Your Ref: OWPC14516
Our Ref: R/64/17/PL 17-03-2017
Please ask for:
Mr D Easton

Demolition of 1 No. dwelling & erection of 4 No. dwellings. This application affects the character & appearance of the Station Road, East Preston Conservation Area.

St. Marys Close Hurst Road Rustington

Thank you for your internet representation made on 8th July 2017 which has been recorded as '**an objection**' with the comments as follows:

Drg No: 151117_SS-01 Rev: D

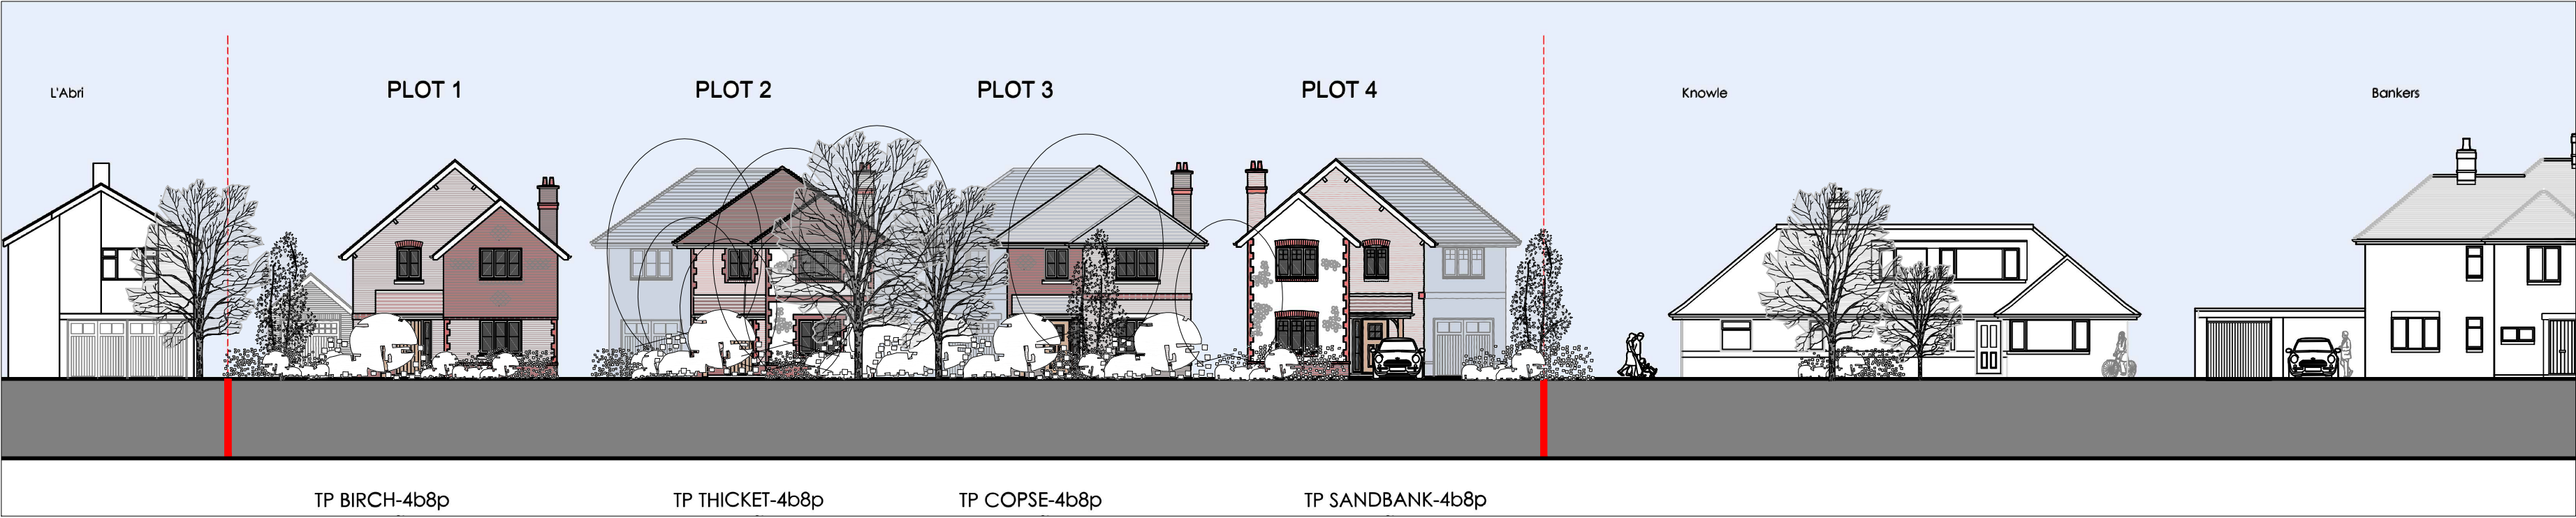
- Density impact and street scene: the cramming of these 4 very similar houses, now with adjoining garages, vainly disguised by different facia rendering, on this plot is in direct conflict of the Council's local plan (D SP1 Design and D DM 1) such as density, mix, massing, frontage and architectural distinctiveness where the latter greatly prevails on Hurst Road.

The illustrations and drawings for this proposal exaggerates the spacing between the 4 houses (now made even more obvious with the attached garages), in a futile attempt to detract from the true impact to the street scene.
